**Final Acceptance Punchlist**  
**El Paso County – Department of Public Works - Stormwater Section**

Project Name:	Redtail Ranch
EDARP Filing Number(s):	SF1821
ESQCP Number:	ESQ1932
Attendees:	DPW SW: Molly Layshock, Mikayla Hartford, Glenn Reese DPW Dev Services: Developer:
Date of Walk-Thru:	05/18/2023
Walk-Thru Number:	1 <sup>st</sup> FA walk

**EASTERLY FOREBAY DETAILS**

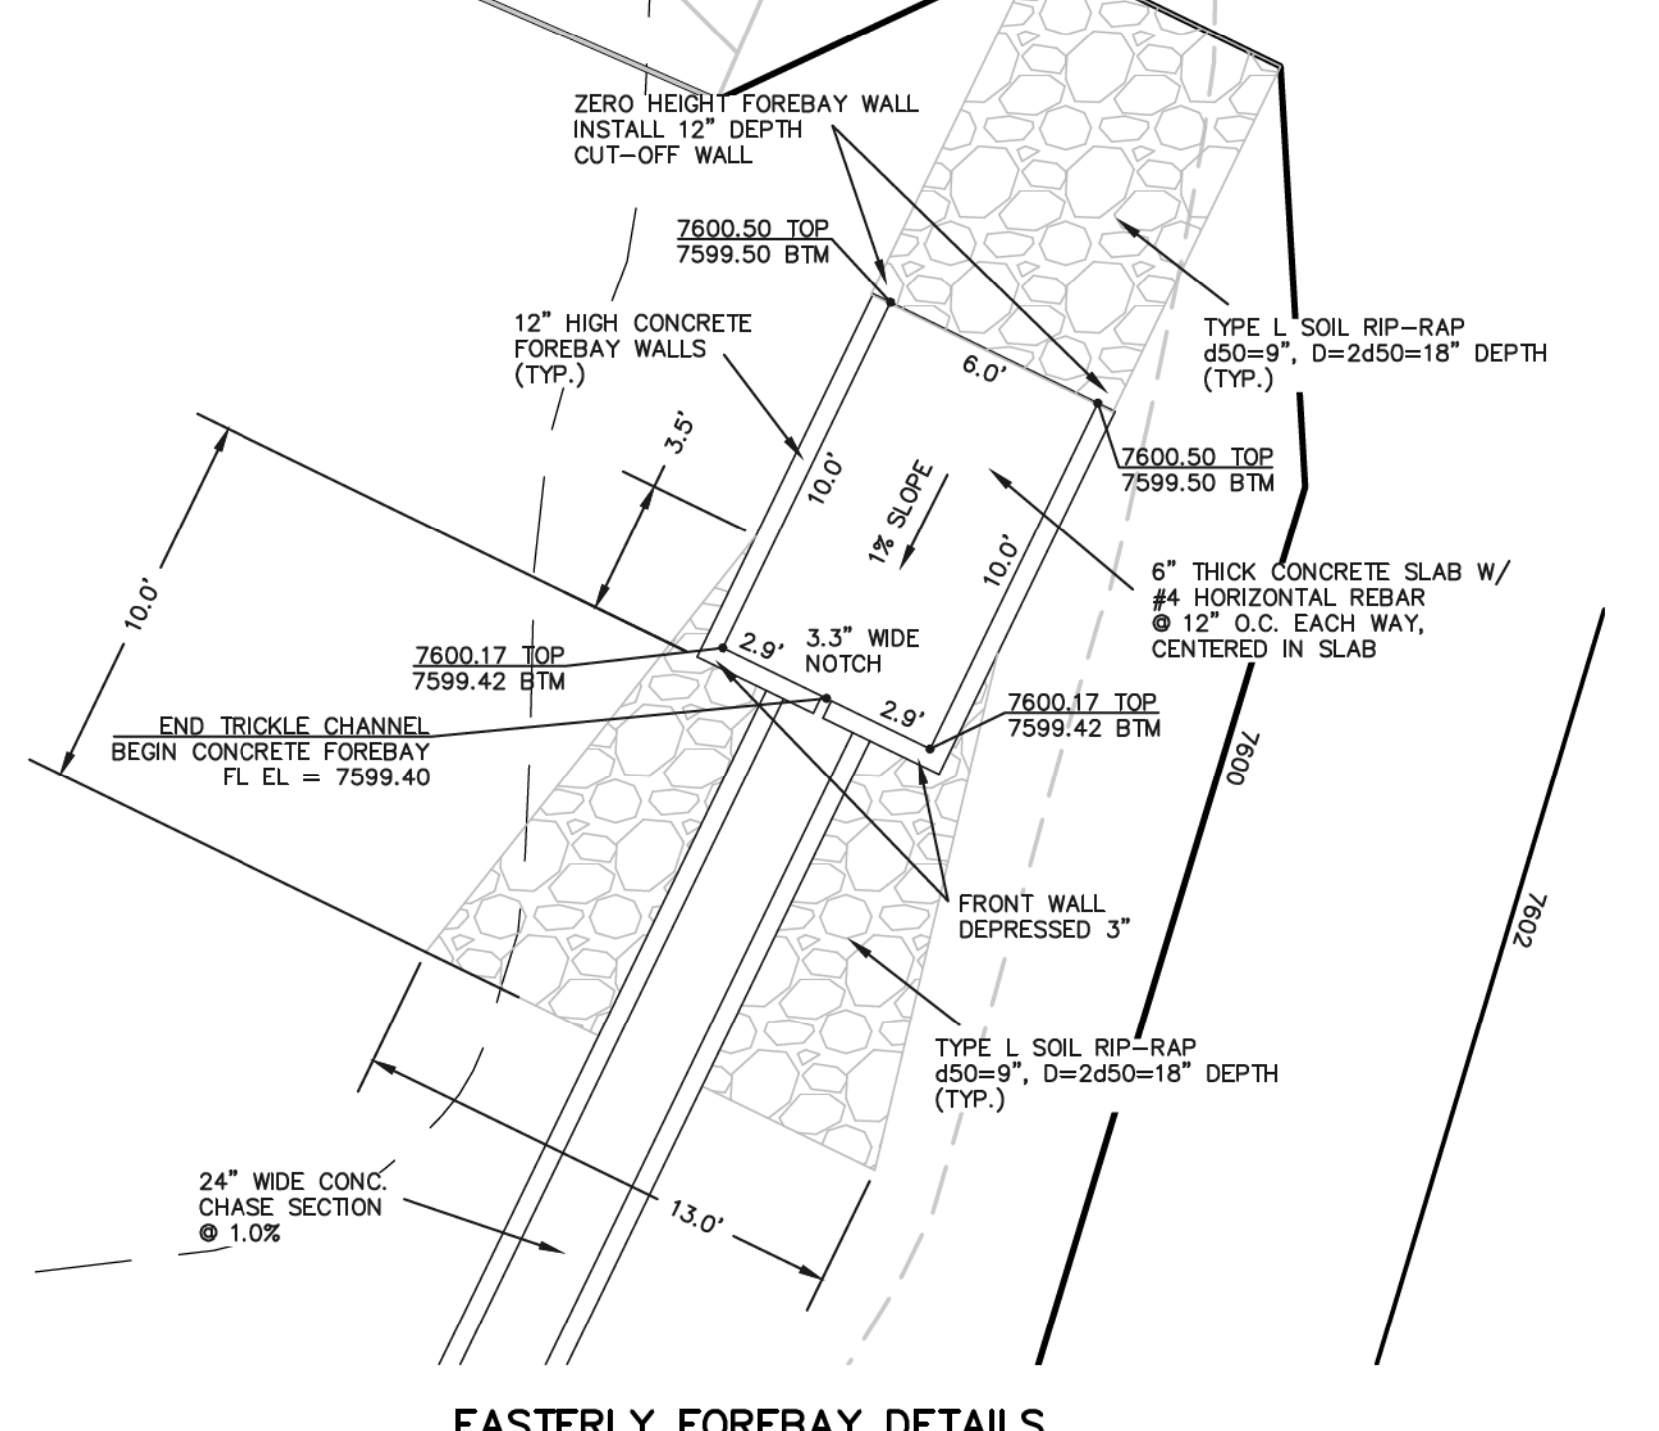
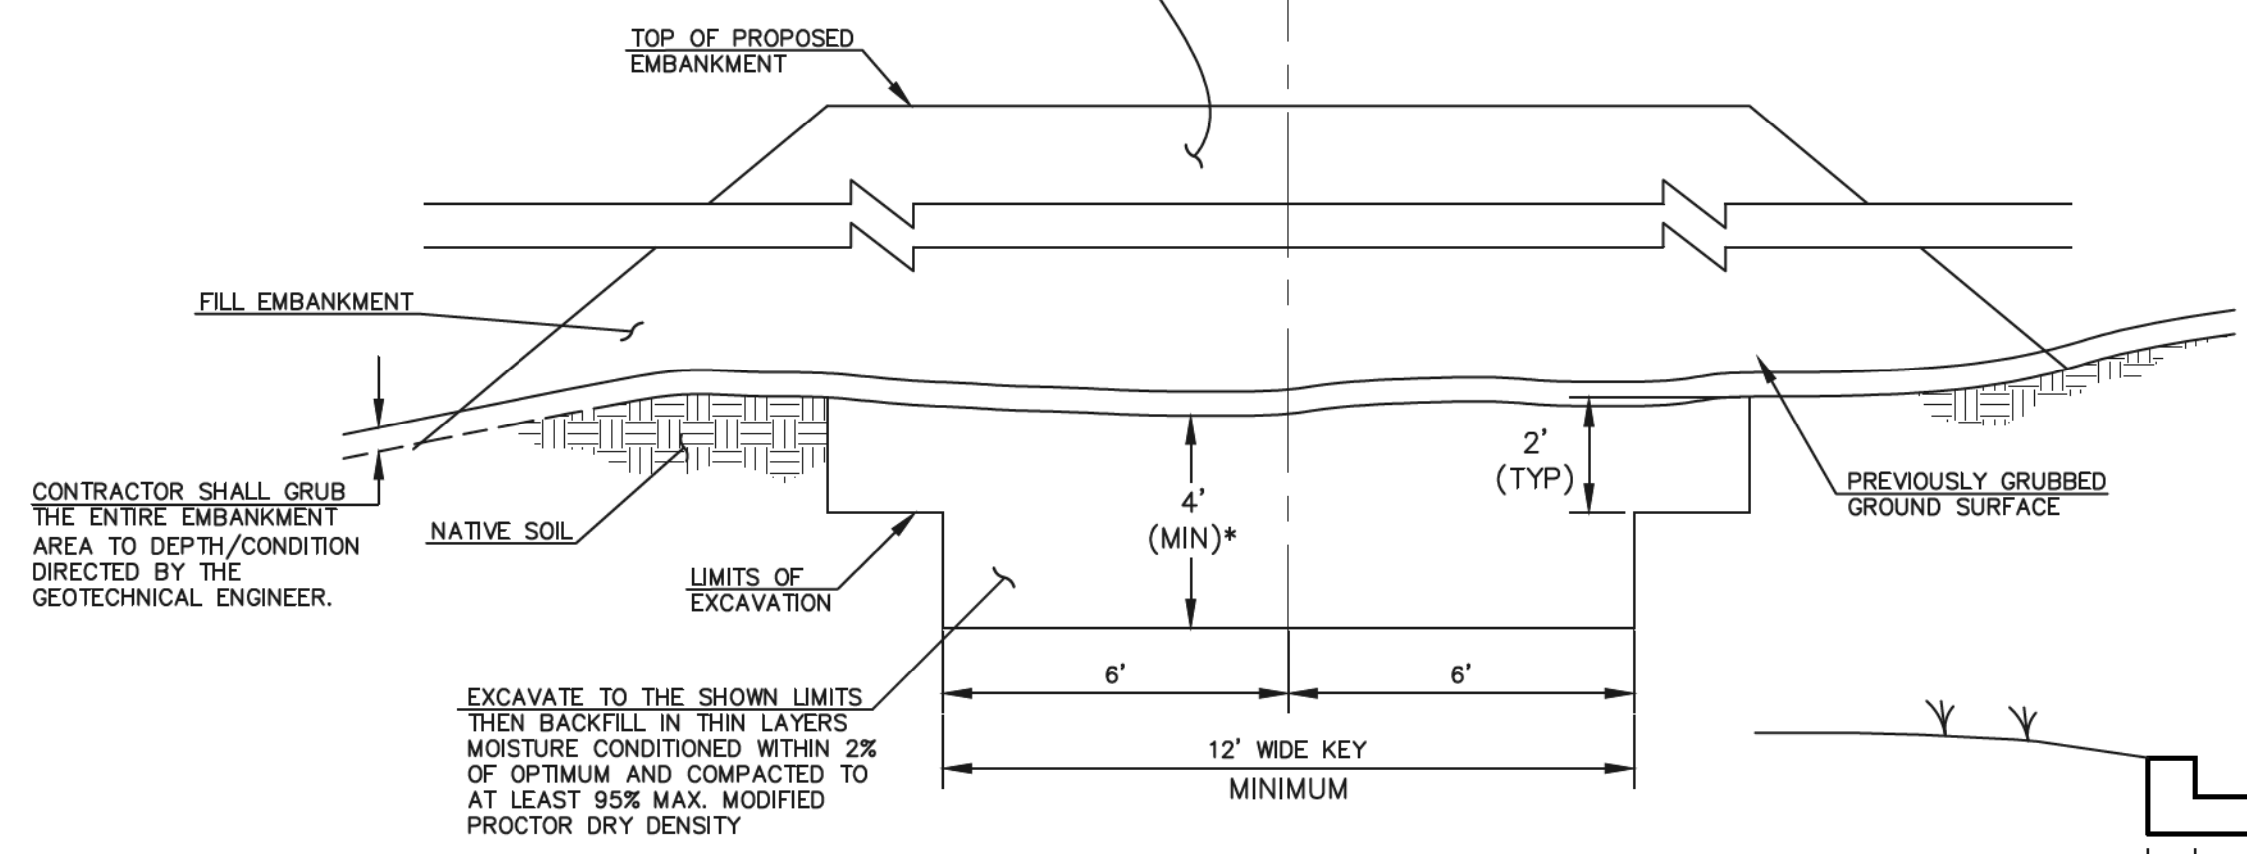
- Major comment: During the FA Walk, Basin 2 was fully drained but Basin 1 had about 18"-24" of standing water. The outlet structure was not clogged but the system was not fully draining (See photo 5). The pond bottom, trickle channel, and forebays could not be fully inspected because they were covered. The pond's drainage issues must be resolved before FA and pond bottom stabilization must be achieved.

- 19"x60" outlet box orifice plate (sheet 9A of 10) measures 60"x60" in the field. Reflect this change on the as-builts
- Adjust grading at check dams upstream of easterly rundown for positive drainage

- Update as-builts to change soil riprap called out on sheet 10 of the plans to be riprap reflecting the change observed in the field. (See comments on as-builts)

- Remove temporary control measures along 24" wide concrete trickle channel
- Wrong well screen is installed in the field. Install proper well screen, diamond well screen is not permitted
